**RE: WASHINGTON STREET NE - 3 OFFICES (C17-D1U9). ENGINEER'S
CERTIFICATION FOR CERTIFICATE OF OCCUPANCY. ENGINEER'S
CERTIFICATION DATED OCTOBER 11, 1996.**

RE: WASHINGTON STREET NE - 3 OFFICES (C17-D1U9) REVISIONS TO APPROVED DG PLAN
DATED 12-4-95

**RE: WASHINGTON STREET NE - 3 OFFICES (C17-D1U9) DRAINAGE AND
GRADING PLAN FOR BUILDING PERMIT APPROVAL. ENGINEER'S STAMP
DATED 11-9-95.**

Drainage and Grading Plan

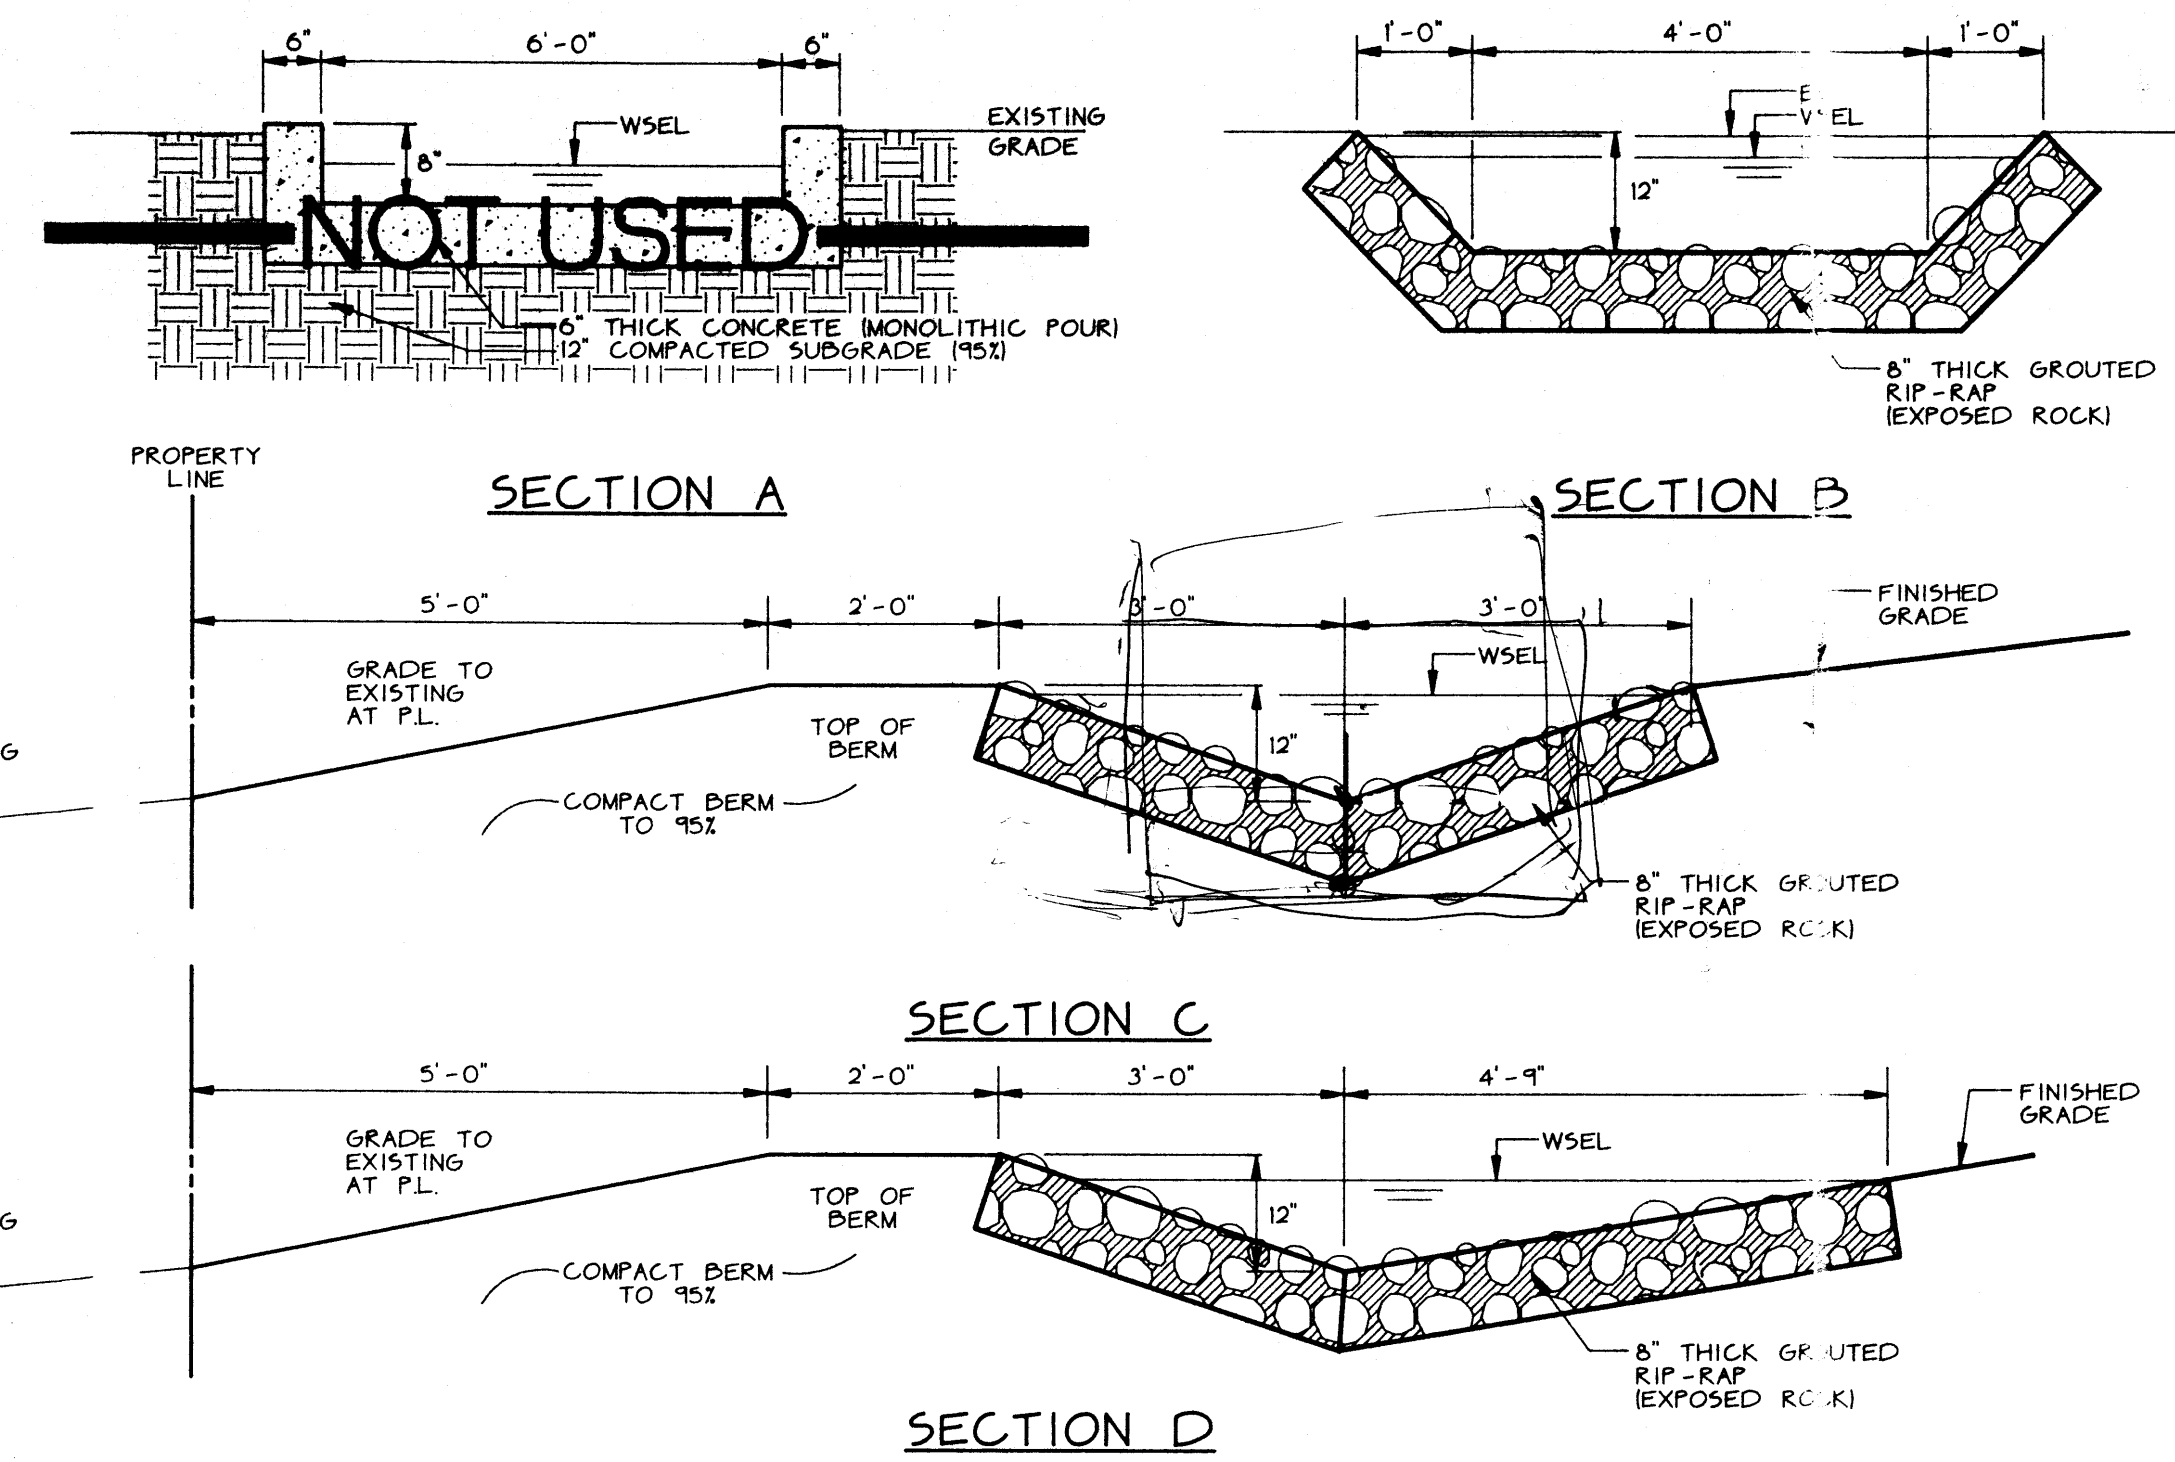
1. Please address sediment control for the area between the proposed channel and the parking lot. An addition to note 12, mentioning "sediment control" would suffice.
2. You may want to consider moving the water blocks at each drive back (west). The slopes from the property line to the street are between 16% and 18%.
